DEVELOPMENT REVIEW BOARD  
**SUPPLEMENTAL SUBMITTAL**

PROJECT NO. PR-2020-003658

DESCRIPTION: Revised Site Plan set with additional notes and details for Transportation; revised utility plan identifying stub to site as private.

DRB Project Number: 2019-003568  
Overture Andalusia

**CP-502**

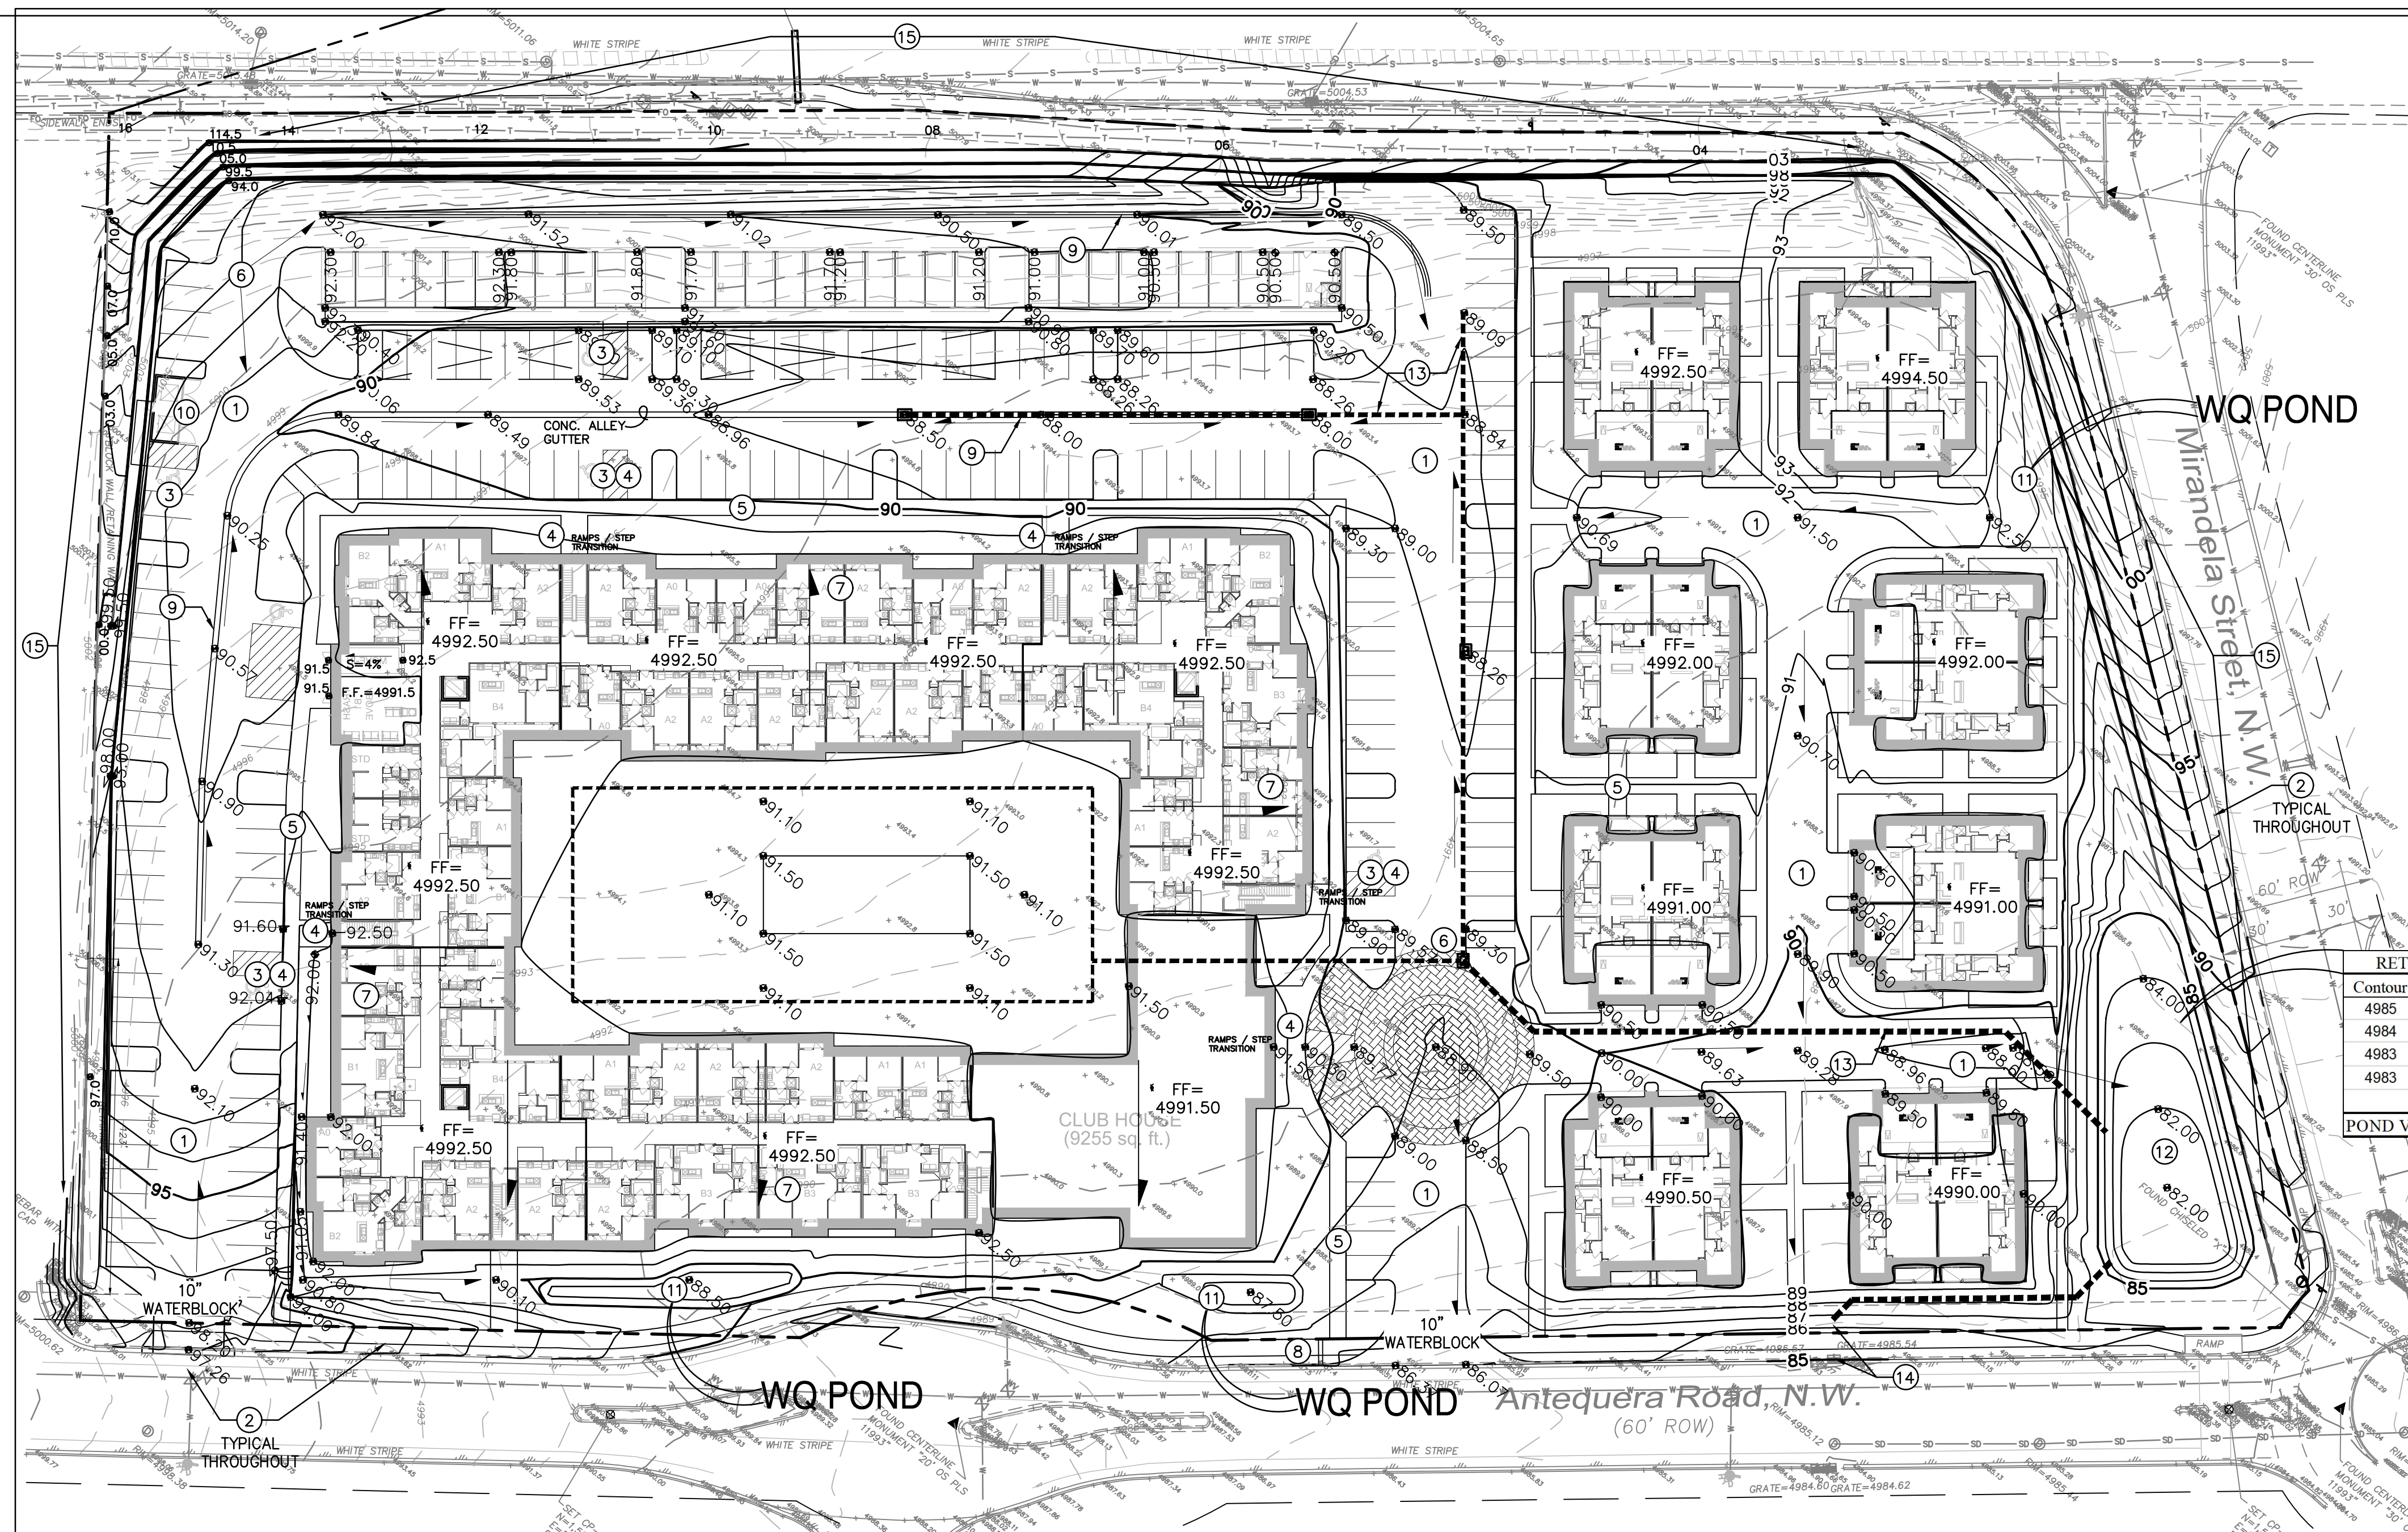
3. Provide details for internal curb ramps. For pedestrian crossings across the parking aisles, it appeared that ramps were still needed to be called out at each end. Make sure all various types of curb ramps are called out. ON the east end of the building at the turn-around, ensure that there is enough of a landing at the top of the ramp

IA Response: Internal ADA compliant curb ramp details provided on CP-502. A-101 keynote #24 for ADA compliant ramp updated with ramp condition type referenced on CP-502. Added dimension at landing of condition type B ramp near main-entry/turn-around area for clarity (6' x 6' landing at top of ramp provided).

KEYED NOTES

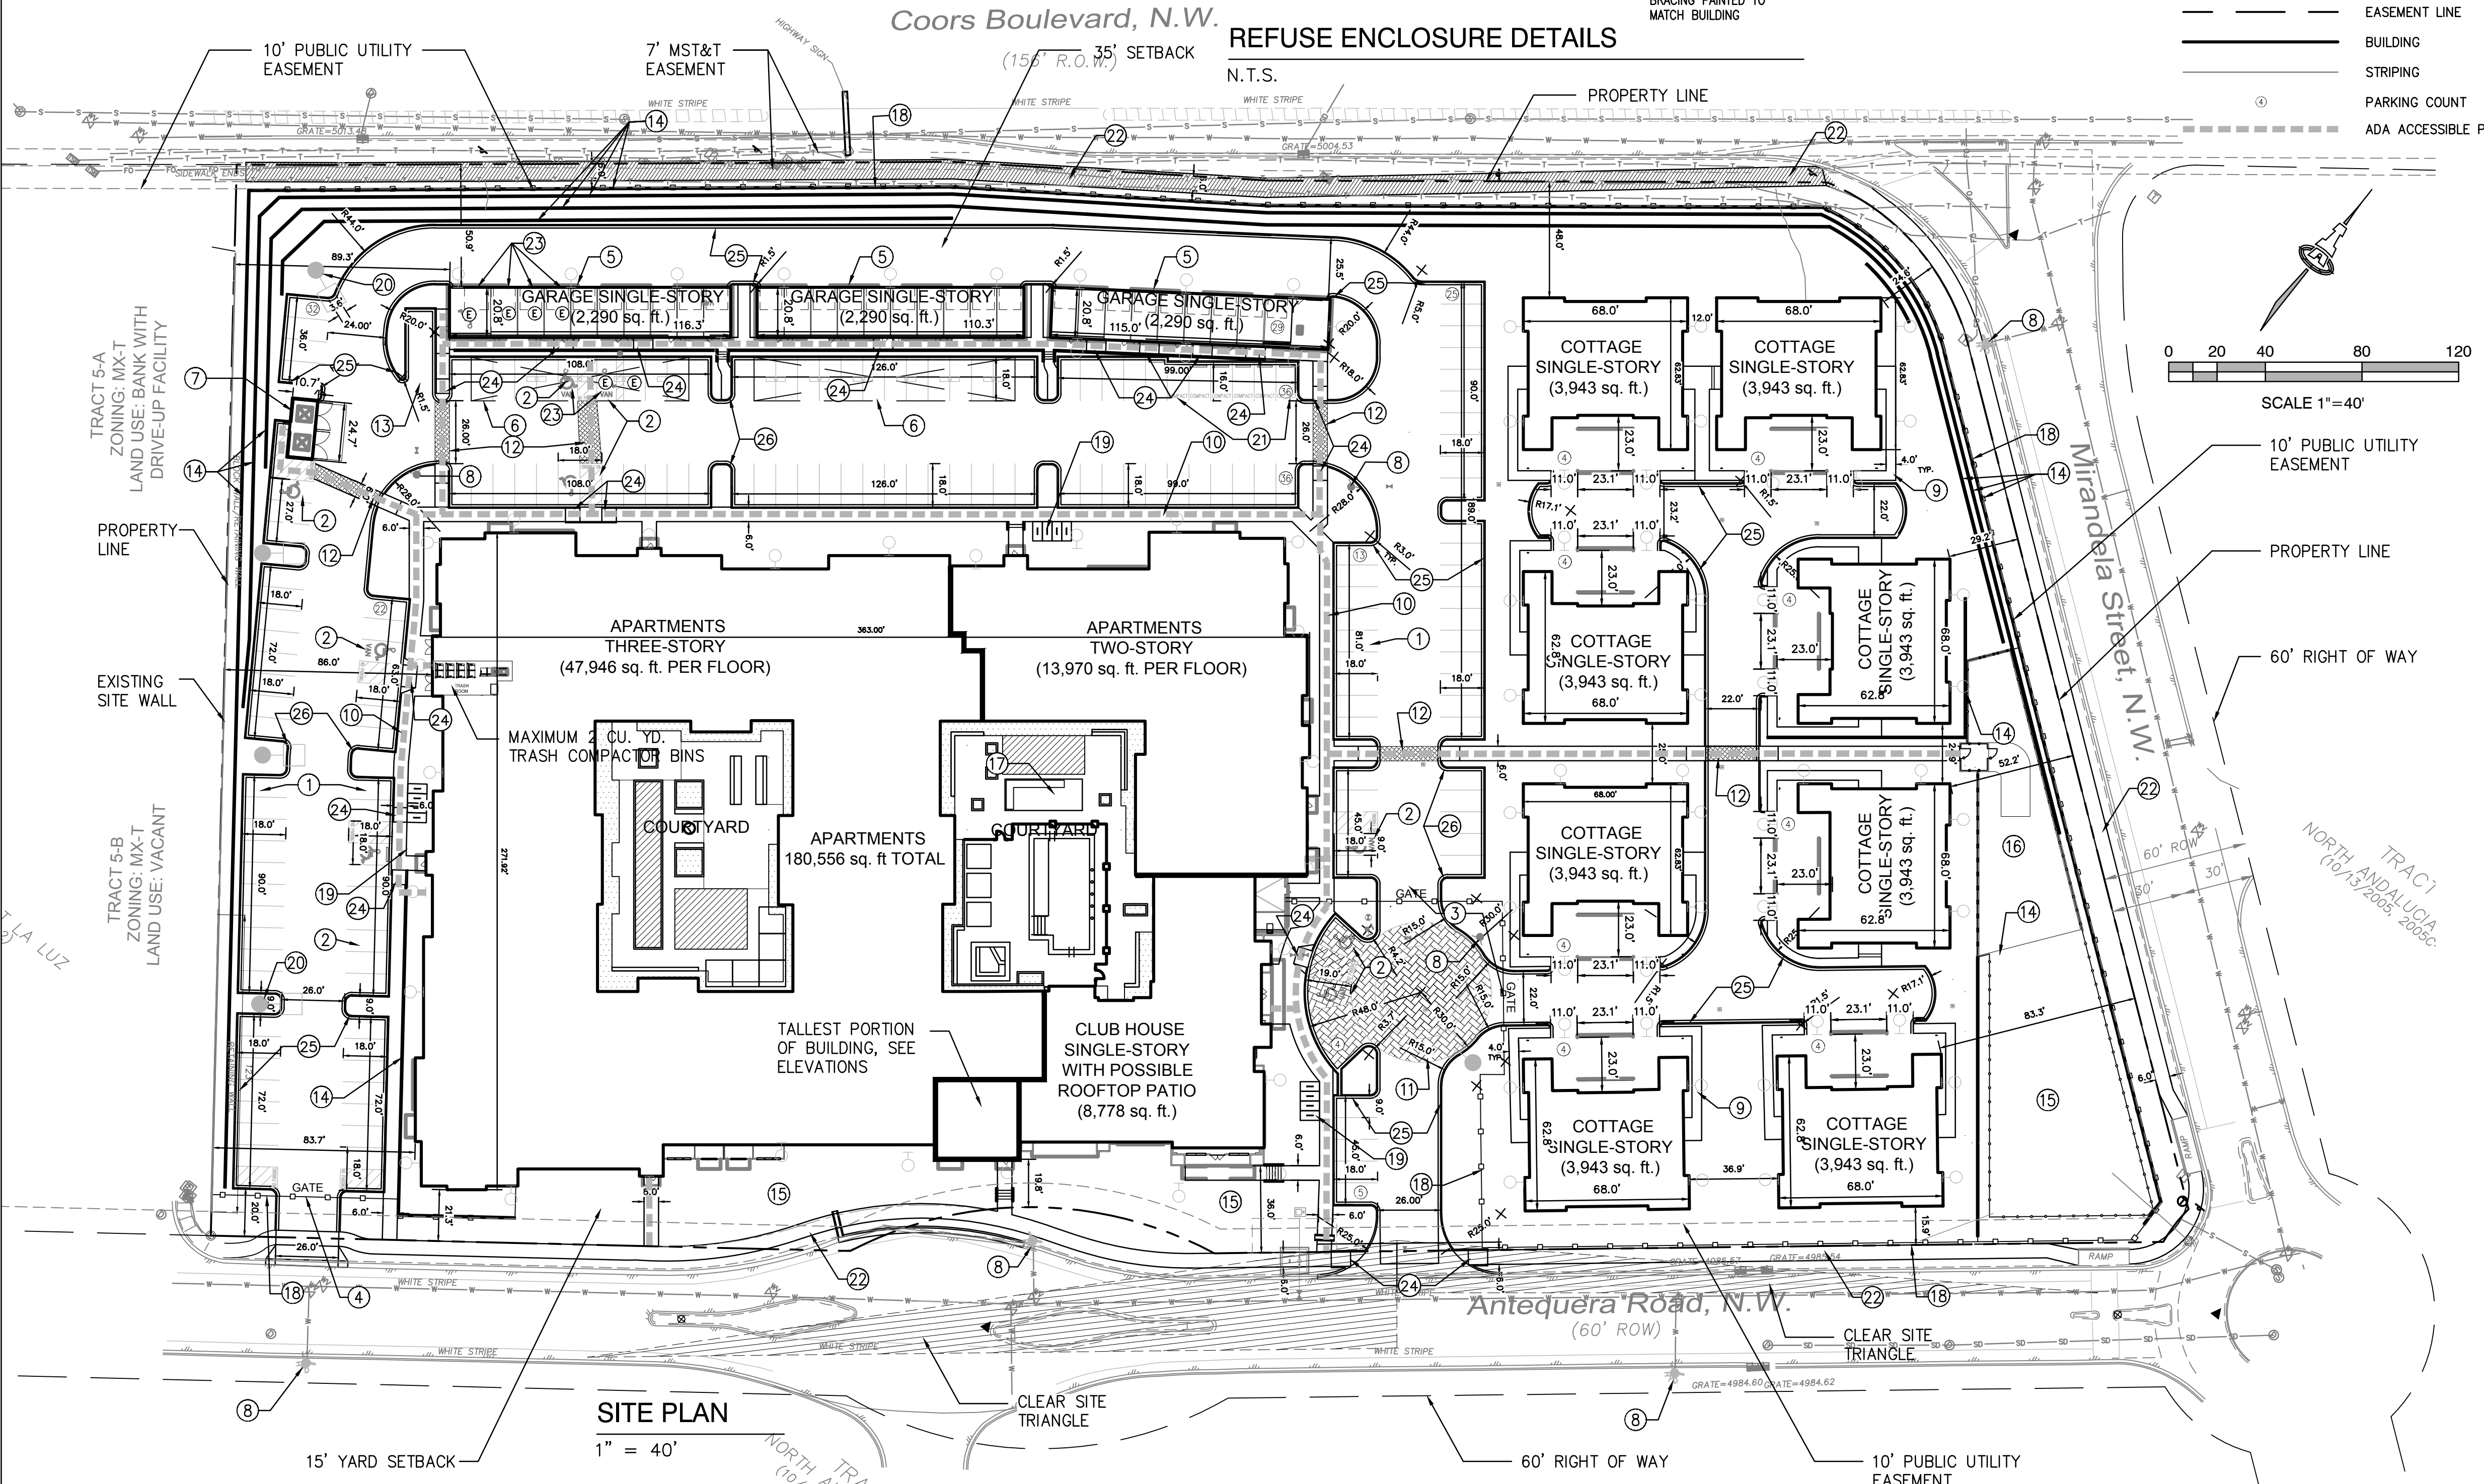
4. Are ramps for the walkways needed at the location of the cottages where you have median curb called out?

5. Some of the pedestrian walkways were not labeled; this was noticed on the far north side of the site.

6. Curb that is 6" to 8" high should be shown to separate parking and aisles from landscaping and sidewalk at all applicable locations.

7. Show and label all curb radii. (On the east side of the site, a few of the larger curb-radii call-outs could not be read; they conflicted with the buildings.)

8. Please add the clear sight triangle to each subdivision entrance on the site plan. Add the following note as well: "Landscaping, fencing and signing will not interfere with clear sight requirements. Therefore, signs, walls, trees, and shrubbery between 3 and 8 feet tall (as measured from the gutter pan) will not be acceptable in the clear sight triangle."

9. Call out all handicapped spaces, and clearly label all van-accessible aisles. One on the north side was not called out. Also, make sure van accessible aisle dimensions are labeled; a typical dimension can be called out, but it is typically at least 8 feet wide.

10. There is a stray note 2 for an ADA space, but it is not shown anywhere near a van accessible aisle on the southwest side. Please clarify.

11. At the Vehicular emergency entrance, include signage that call out "Emergency Vehicles Only".

12. I could not identify all of the electrical charging spaces per Note 23.

13. Call out width of parking aisle north of turn-around.

IA Response: Access is only intended through the middle 6' wide sidewalk to the dog park area. Sidewalks adjacent to the cottages are intended for individual building/unit use from unit garage to unit entry, not intended to interconnect with each other.

IA Response: Additional key note labels added for the pedestrian walkways.

IA Response: Added additional keynote #25 for clarity, no 8" curbs are proposed on site, only 6" curb.

IA Response: Additional curb radii dimensions added across site, 3'R is standard on curb radii unless otherwise noted on Site Plan.

IA Response: Clear sight triangle added to public vehicular ingress/egress location. Note added as General Note #5.

IA Response: Verified labeling for all ADA parking spaces on site, added access aisle dimensions adjacent to ADA Van stalls.

IA Response: Previously shown in error, removed from plan view.

IA Response: Added keynote calling out "Emergency Vehicle Access Only" sign locations on plan sheet. Added sign detail to sheet CP-503.

IA Response: Added electrical parking symbol to legend and updated keynote description for clarity. Provided only 2 electrical vehicle charging spaces within the open parking area. Other 4 stalls are noted as the south-western most stalls in the single-story garages.

IA Response: Added parking aisle width dimensions north of turn-around.
